PCU038797

Submission form

Epping to Thorleigh Third Track proposal

Figure S.6 Cross-section and elevation - New Cheltenham Station concourse building (see also S.5 for artist's impression)

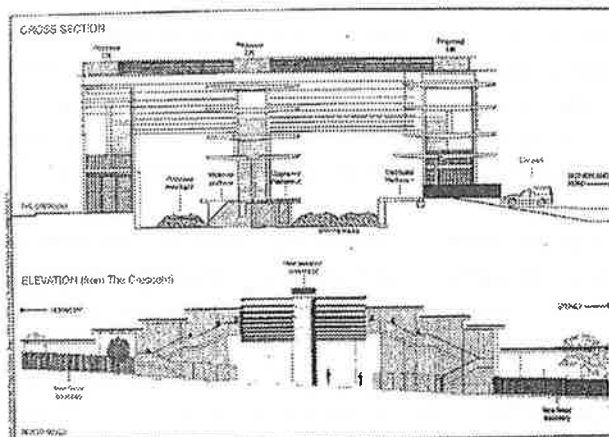
AT THE INFORMATION EVENING AT CHELTENHAM REC. CLUB
ON WEDNESDAY 10th OCTOBER, I WAS ADVISED THAT THE
FOLLOWING PROPOSAL FOR ACCESS TO CHELTENHAM
STATION HAD NOT BEEN ~~BEEN~~ CONSIDERED.

THE END OF THE PLATFORMS ARE ADJACENT TO THE
EXISTING ROAD BRIDGE. CONSTRUCTION OF A
CONCOURSE BETWEEN THE 2 PLATFORMS ADJACENT TO
A LEVEL WITH THE EXISTING FOOTPATH CONTAINING
THE TICKET OFFICE & OTHER ROOMS IF REQUIRED WITH
LIFTS & STAIRS TO EACH PLATFORM.

THE EXISTING FOOTPATH IS NOW USED BY THE
RESIDENT TO ACCESS THE STATIONS. THE PLATFORMS
ARE IN A CUTTING AT THE BRIDGE.

A PROPOSAL AS ABOVE WOULD ONLY NEED 2 LIFTS
INSTEAD OF 3, NO MAJOR SETS OF STAIRS TO REACH THE
CONCOURSE AS SHOWN ON THE PRESENT PROPOSAL
AND WOULD NOT CREATE THE EYESORE THAT YOU
PROPOSE.

IF THIS IS POSSIBLE IT COULD SAVE SOME OF THE
OBJECTION THAT I'M SURE YOU WILL HAVE TO YOUR
PROPOSED STATION ACCESS
